A47 Blofield to North Burlingham Dualling

Scheme Number: TR010040

Volume 9 **9.6 Schedule of Changes to dDCO**

Schedule of drafting changes for dDCO Deadline 4

DRAWING TITLE  
**CLASSIFICATION OF ROADS PLANS REGULATION 5(2)(o) SHEET 2 OF 8**

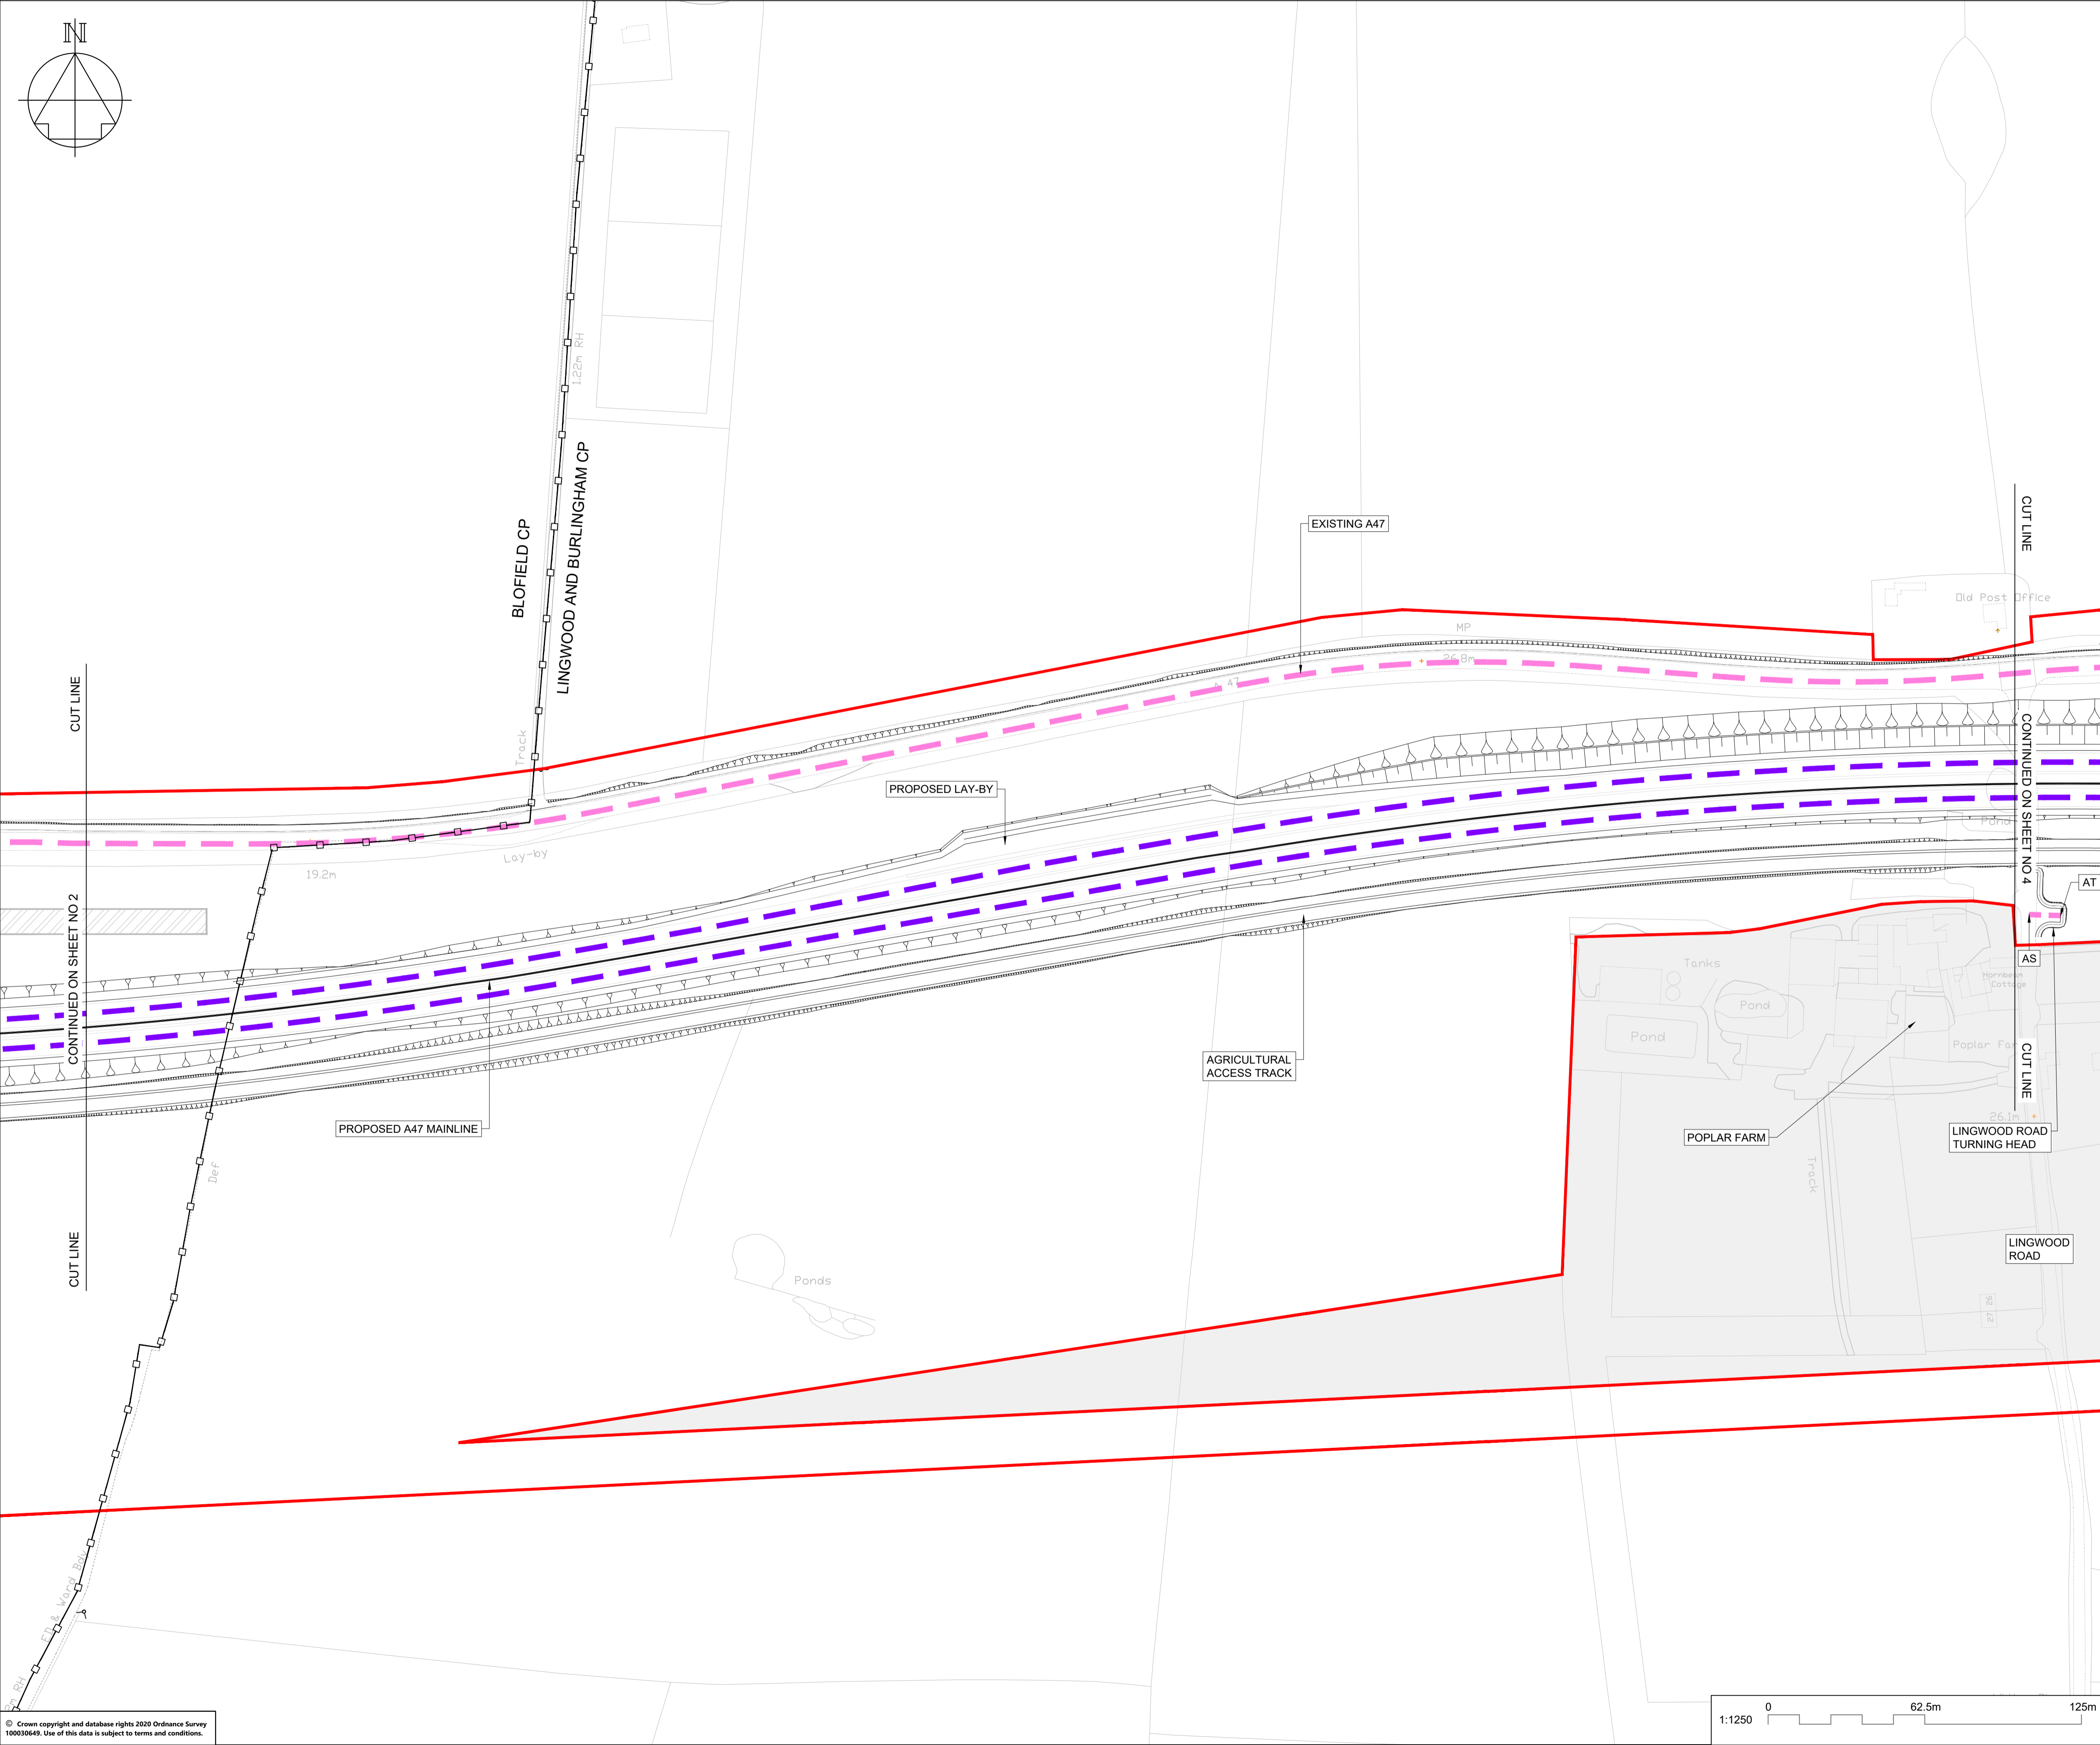
<p>Schedule 3 ' Classification of Roads, etc'</p> <p>Part 6, 'Footpaths, cycle tracks, footways and bridleways',</p>	<p>Under the heading "The rights of way and access plans – sheet 2" the amendment of the third row to:</p> <p>(1) Replace references to F7 and F8 with SU18 and SU21 respectively.</p> <p>(2) Delete the word "footway" and substitute the word "cycle track".</p>	<p>This amendment is required to reflect the proposed change of footpath south of the new A47 to a cycle track. This change is to address comments made by Norfolk County Council and other interested parties</p>	N/A	N/A

Article/Schedule	Change	Reason for change	Precedent used	Consequential changes
		during the examination.		
<p>Schedule 3 ' Classification of Roads, etc'</p> <p>Part 6, 'Footpaths, cycle tracks, footways and bridleways',</p>	<p>Under the heading "The rights of way and access plans – sheet 2" the deletion of the fourth row.</p>	<p>This new right of way has been subsumed into the third row and upgraded to a cycle track. This amendment is required to reflect the proposed change of footpath south of the new A47 to a cycle track. This change is to address comments made by Norfolk County Council and other interested parties during the examination.</p>	N/A	N/A
<p>Schedule 3 ' Classification of Roads, etc'</p> <p>Part 6, 'Footpaths, cycle tracks, footways and bridleways',</p>	<p>Under the heading "The rights of way and access plans – sheet 4" a new row as follows:</p> <p>(1) In column (1) the insertion of the words "Lingwood and Burlingham";</p> <p>(2) In column (2):</p> <p>"Reference SU14 to SU15</p> <p>A cycle track in the verge on the northern side of the detrunked A47 from point SU14 at the eastern side of Dell Corner Lane, in an easterly direction to</p>	<p>This amendment is required to reflect the inclusion of a new cycle track from Dell Corner Lane to Main Road.</p> <p>This change is to address comments made by Norfolk County Council and other interested parties during the examination.</p>	N/A	N/A
